## Online Comment

**Application** H13-0292-25  
**Location** Holly Tree House Fengate Moulton Chapel PE12 0XR  
**Proposal** Proposed replacement dwelling

**Name** Gregory Watkinson, Conservation Officer  
**Address** Conservation Officer

Car Port - Plan
1 : 50

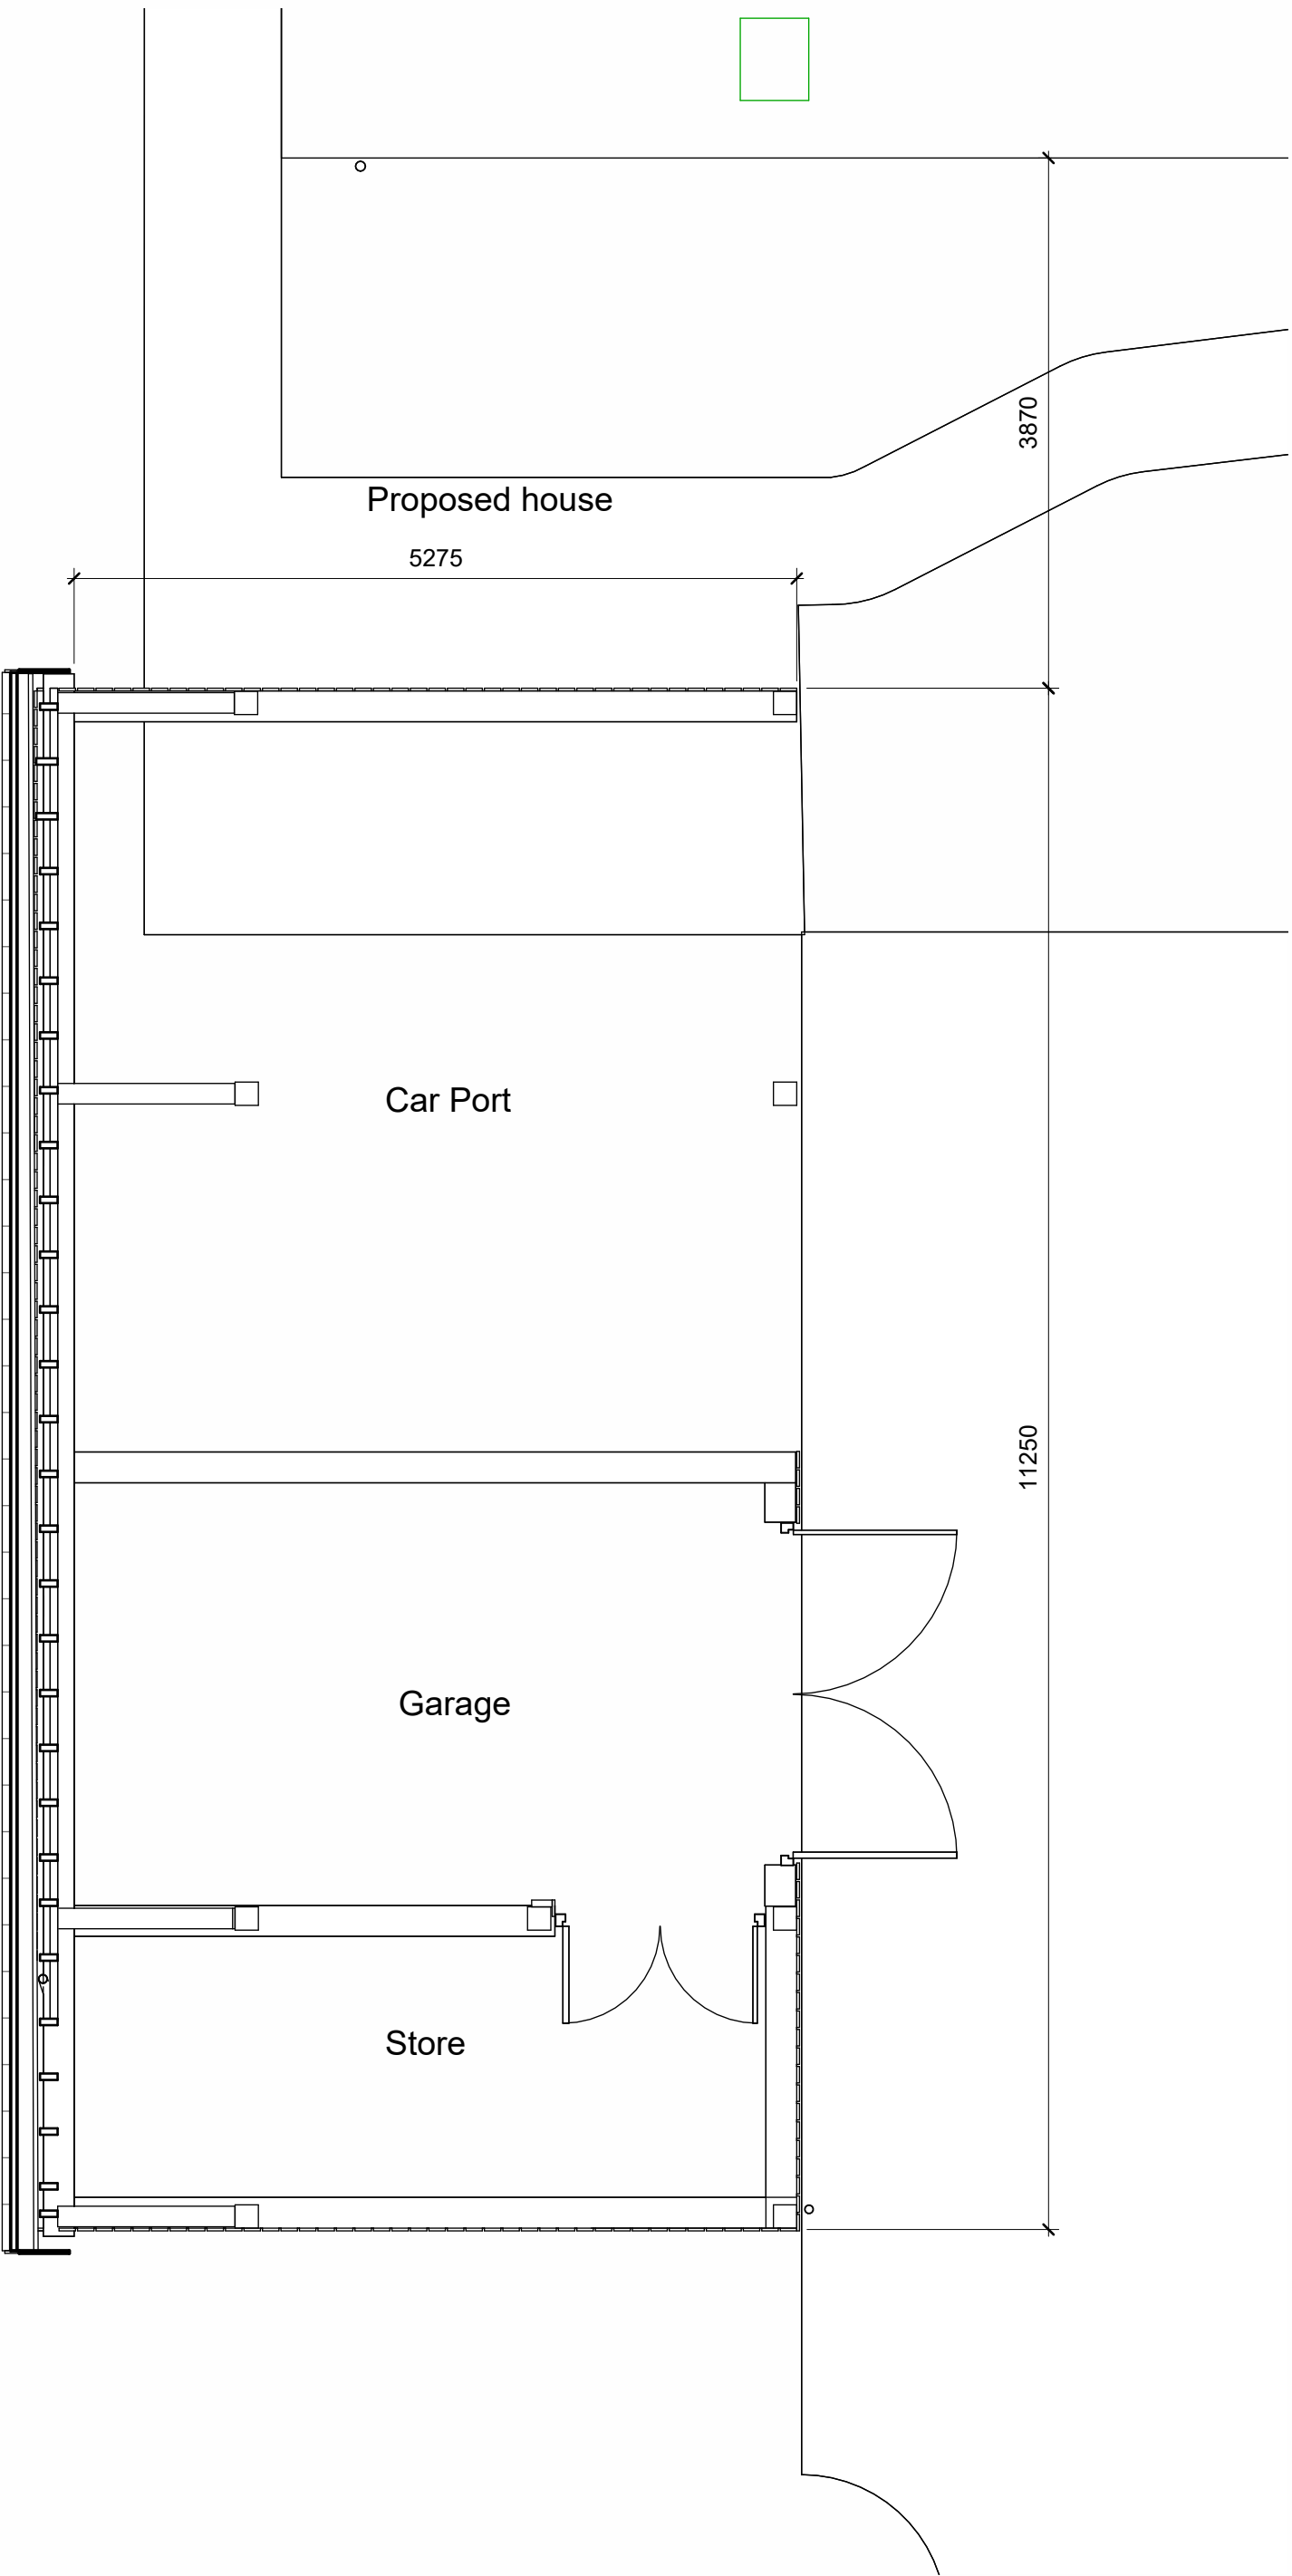
I would, however, request that with an approval, the determination should be made conditional, pending details of external materials, windows, doors and rooflights for both the house and the car port.

Arguably in this case the proposed car port poses a greater influence on the manner in which the adjacent listed building is appreciated as it would directly feature in views of that structure as travelling northbound along Fen Gate. I am satisfied that both the design and scale would not place that at risk. However, it is imperative that control over the final materials and detailing is given to the LPA in this instance.
